Address: 2 Eunice Lane Huddersfield HD88PB

Application number: 2023/91280	
What is the application for?:	Quarrying operations for the extraction of clay, shale and incidental coal and s
Address of the site or building:	Bromley Farm Quarry, Barnsley Road, Upper Cumberworth, Huddersfield, HD8 8PD
Postcode:	S36 4HG

User comments

HGV ROUTING PLAN

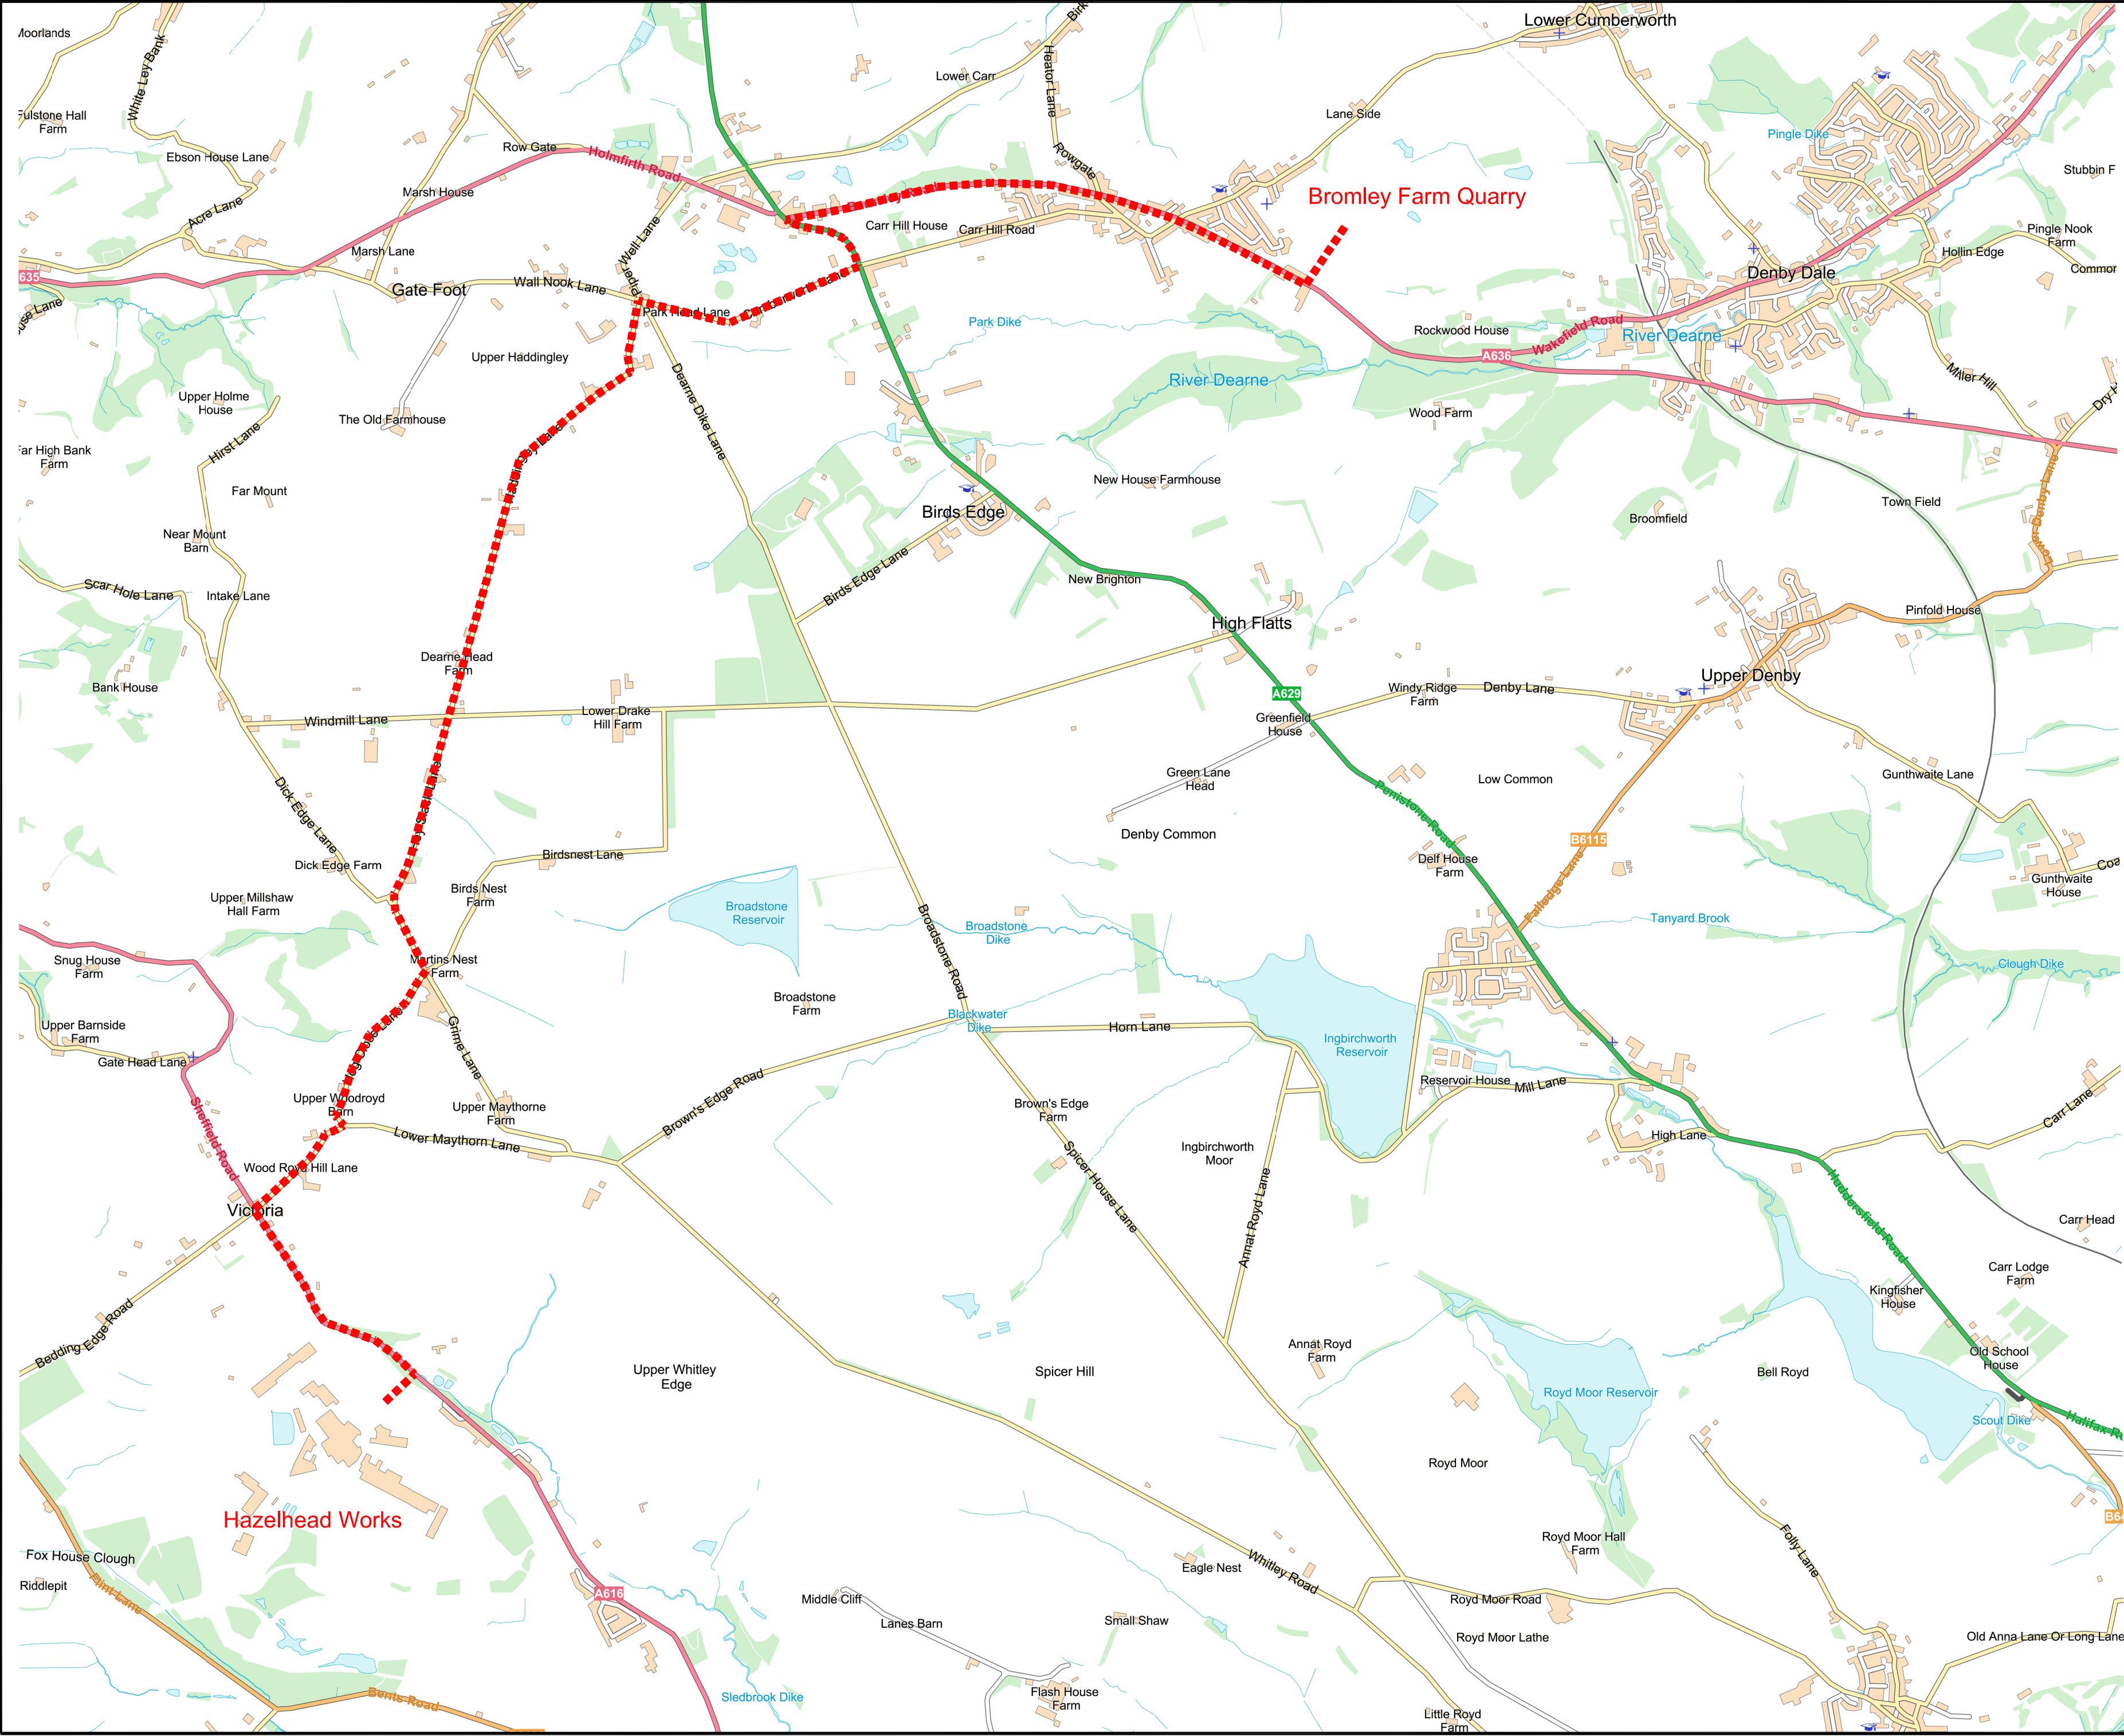
Whilst the intended route for traffic is via a main road the use of Carr Hall road to get to the processing plant 4.8 miles away (not approx 5km as mentioned in the report) has a high potential to impact on local walkers and residents alike. Many people use the public footpath that exits onto Carr Hall road and at present there is no pedestrian walkway to segregate vehicles and people, some of which will be school children using sustainable means of transport (walking) to the highly thought of local school.

I am baffled that this conclusion can be written in good conscience. Every 6 minutes there will be an HGV leaving or entering the proposed plant. Every 6 minutes there is either going to be a vehicle on Carr Hill Road (endangering local residents and walkers) or every 6 minutes queuing at the Sovereign Junction.

The data regarding accidents only seems to have considered the "vicinity of the site". Crashmap data as used by the report shows 2 "serious" incidents on the Carr Hall Road route (2018 and 2021). 3 slight at the junction of Barnsley Road/ Carr Hall road junction and then should the HGV's follow what will likely be the "planned route" at Sovereign Junction 3 more slight incidents.
